## Engineers Comments Regarding Surface Water Drainage

| <b>Application Reference:</b>   | WA/79/26/DOC                                                                                                  | <b>Reviewer Reference:</b> | ADC/EXT5/AF |
| <b>Site Name:</b>               | Stoneybrook Farm Eastergate Lane Walberton BN18 0BA                                                           |                            |             |
| <b>Application Description:</b> | Approval of details reserved by condition under WA/108/24/PL relating to condition 3- Surface Water Drainage. |                            |             |

Section - Headwall Gabion Cage Filter (Outlet)

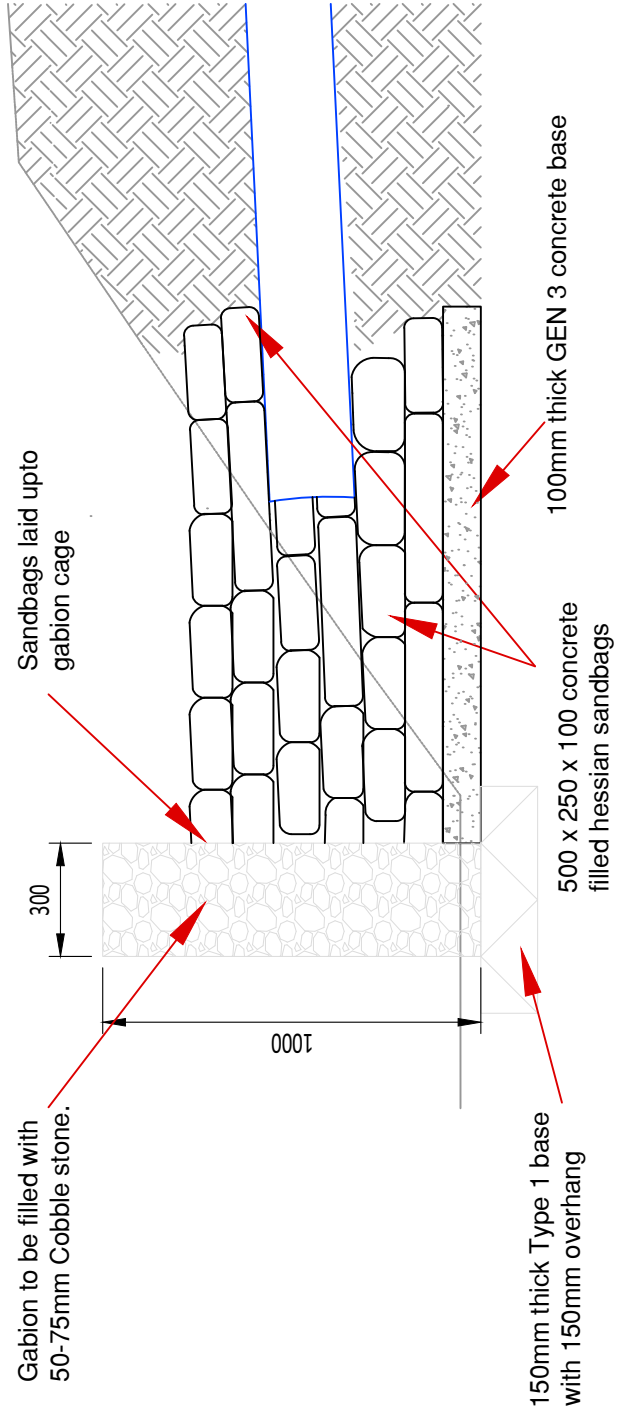
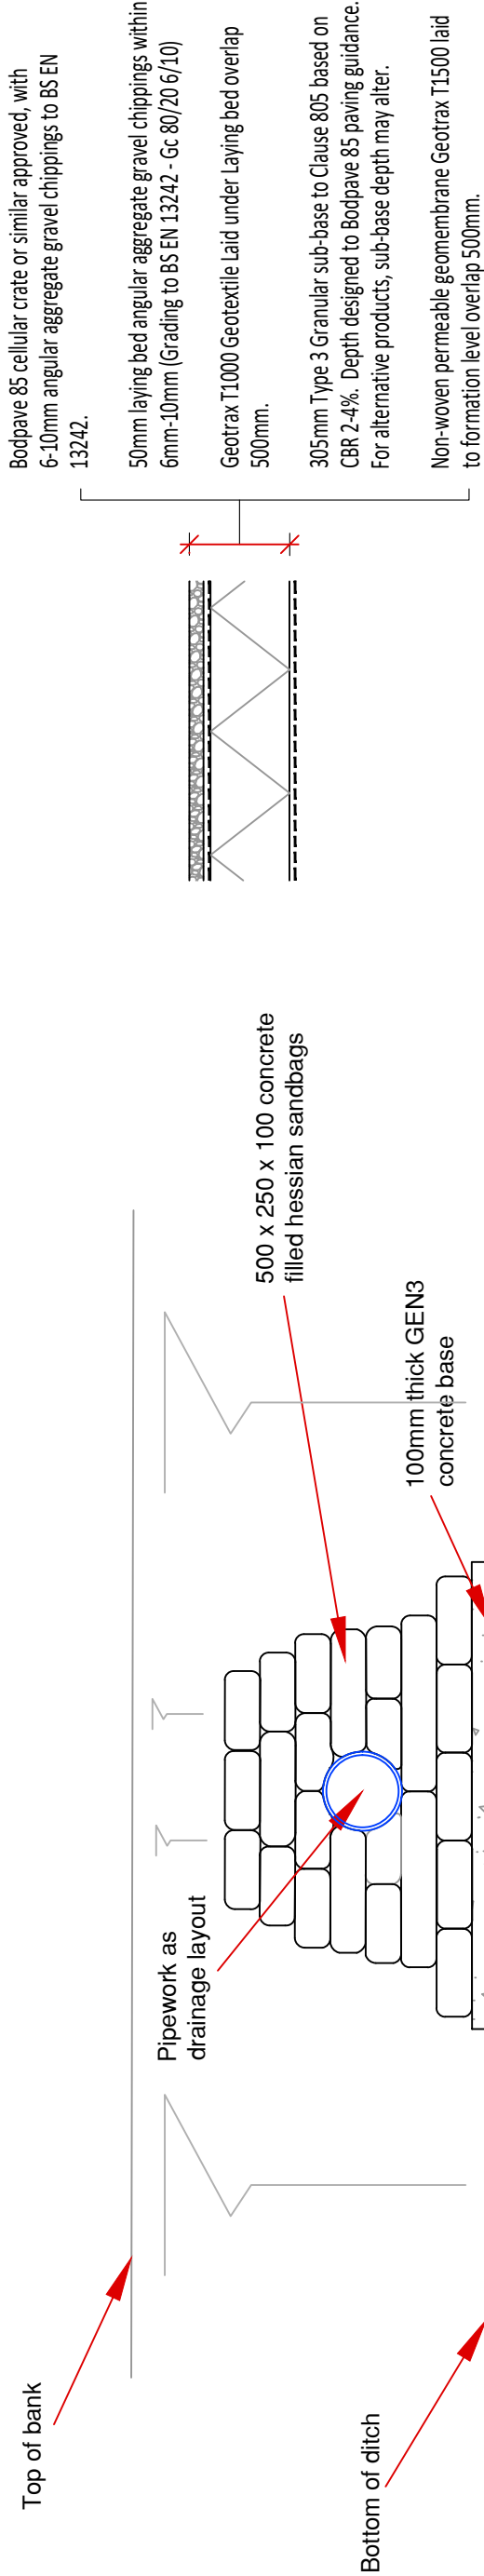
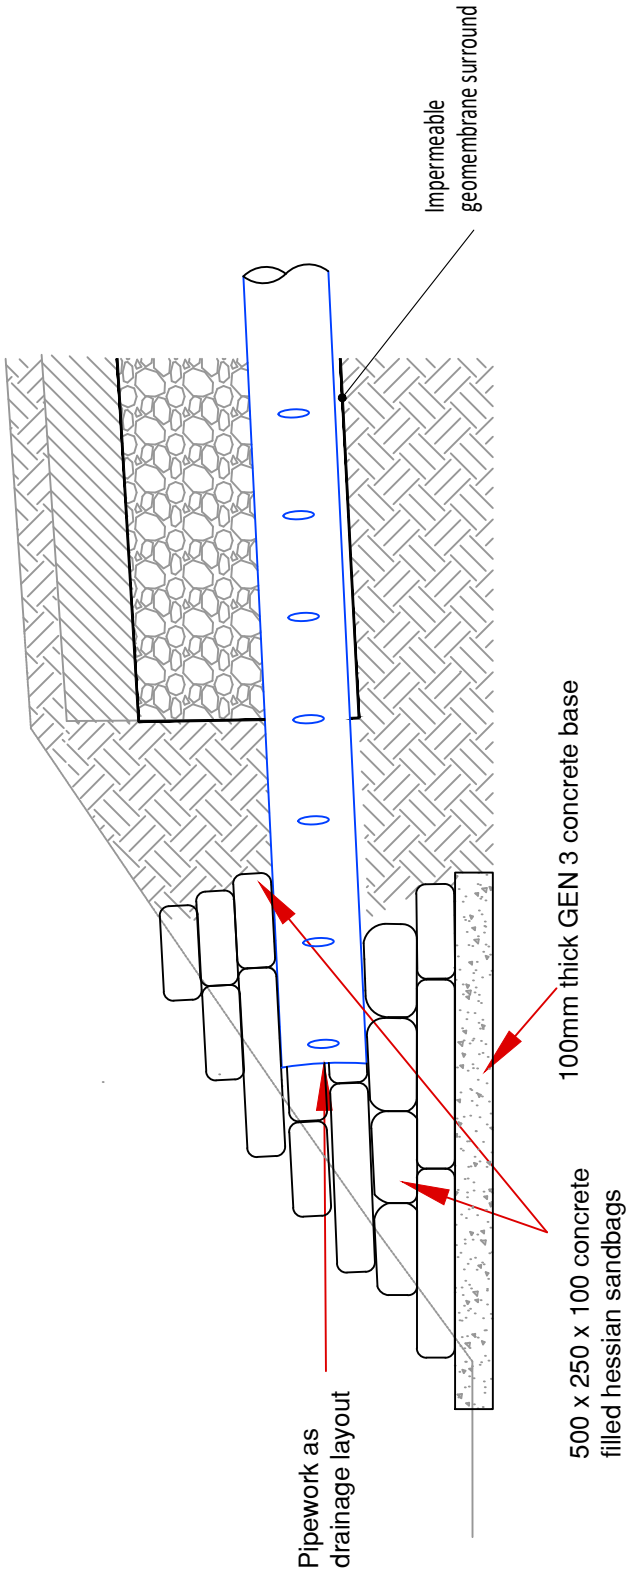
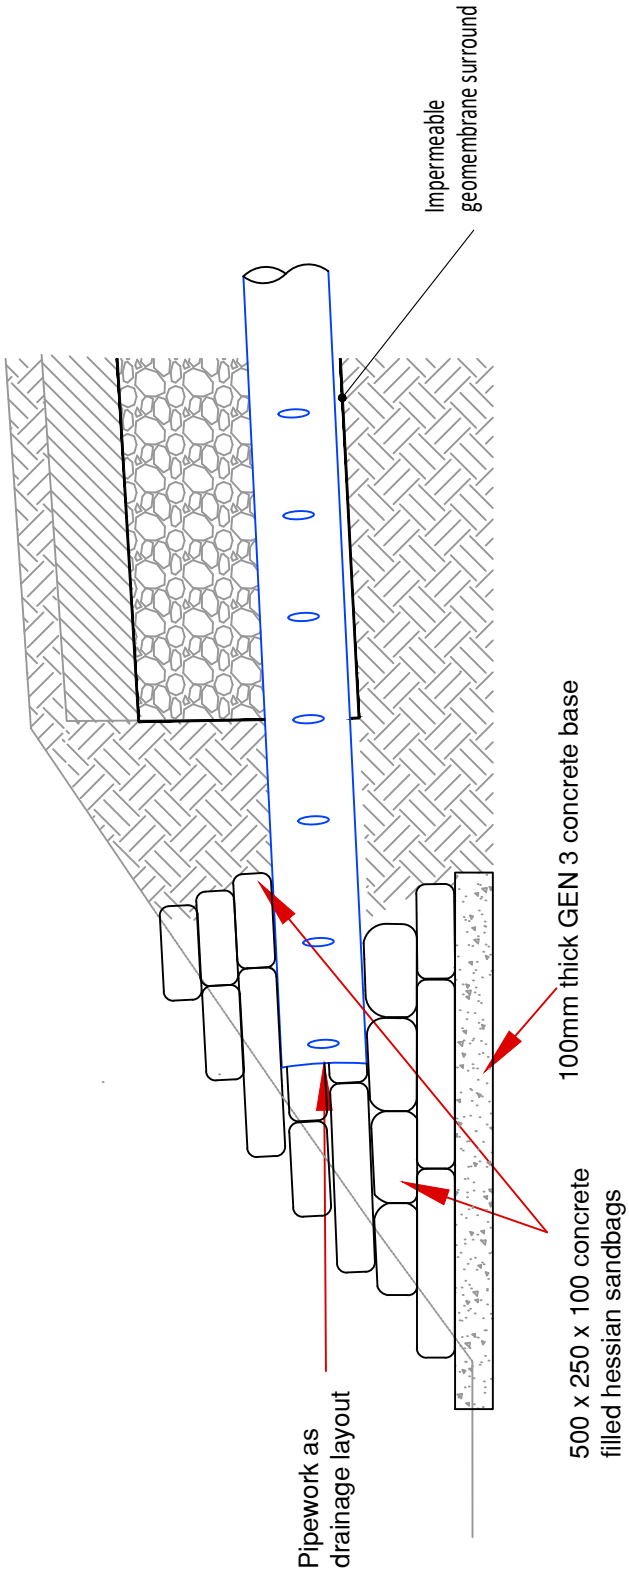
| 7. | <p>Measures to mitigate blockage of the flow control device should be incorporated at the basin headwall and flow control chamber.</p> <p>Designer Response<br/>03/06/2026<br/>Gabion cage is proposed in front of the outlet headwall to provide a filter process and remove debris that could cause blockages. Construction detail provided.</p>                                                                                                                                 | <p>The gabion inlet provides suitable blockage reduction from the open feature. Details should be provided for the flow control chamber to include blockage protection.</p> | <p>Contraflow chamber specified with upstream filter guard</p> | <p>The solution is acceptable, however, this is not reflected on Construction Details drawing A001-013/302.</p> |  |

Basin Embankment Detail

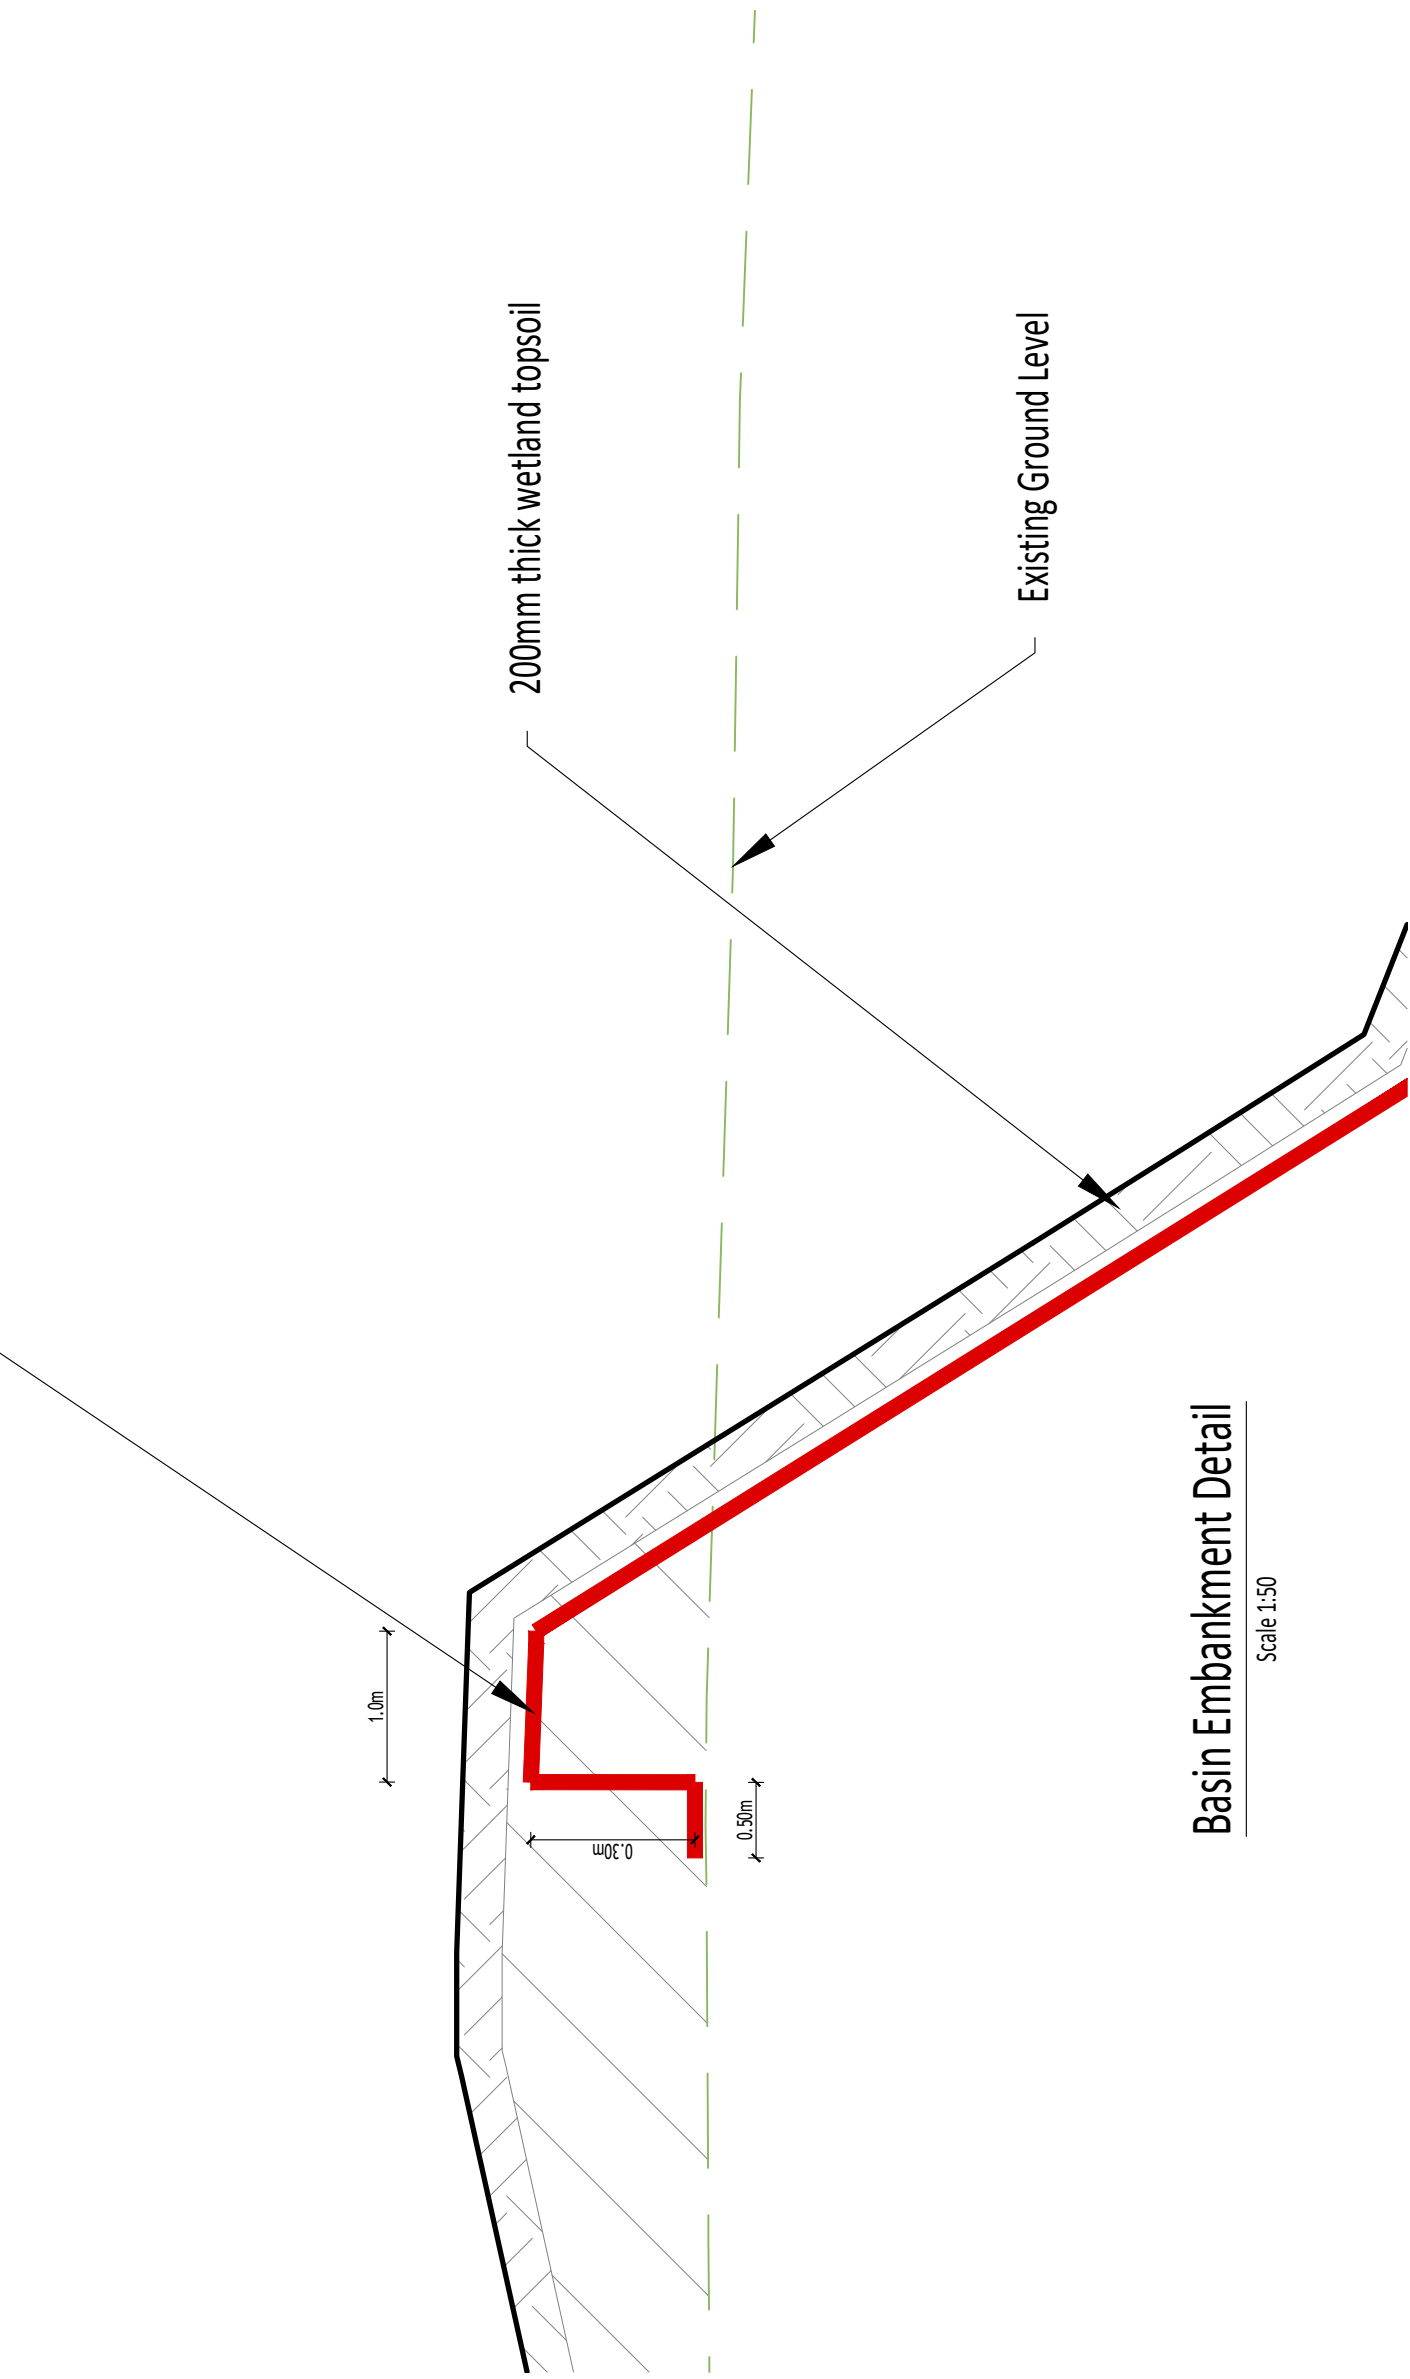
| 5. | <p>Anti-floatation calculations should be provided for the basin.</p> <p>Designer Response<br/>03/06/2026<br/>The base of the basin will remain as dug material to allow the ground water to rise into the pond during the winter time and allow some infiltration during periods where no groundwater is present</p>                     | <p>This is not acceptable as groundwater may reduce available volume for infiltration.</p> | <p>Flotation calculations added</p> | <p>Comment closed.</p> |  |
| 6. | <p>Construction details should be provided for the basin construction and liner.</p> <p>Designer Response<br/>03/06/2026<br/>Details have been provided</p>                                                                                                                                                                               | <p>The detail will need to be revised, see comments above.</p>                             | <p>Liner added</p>                  | <p>Comment closed.</p> |  |
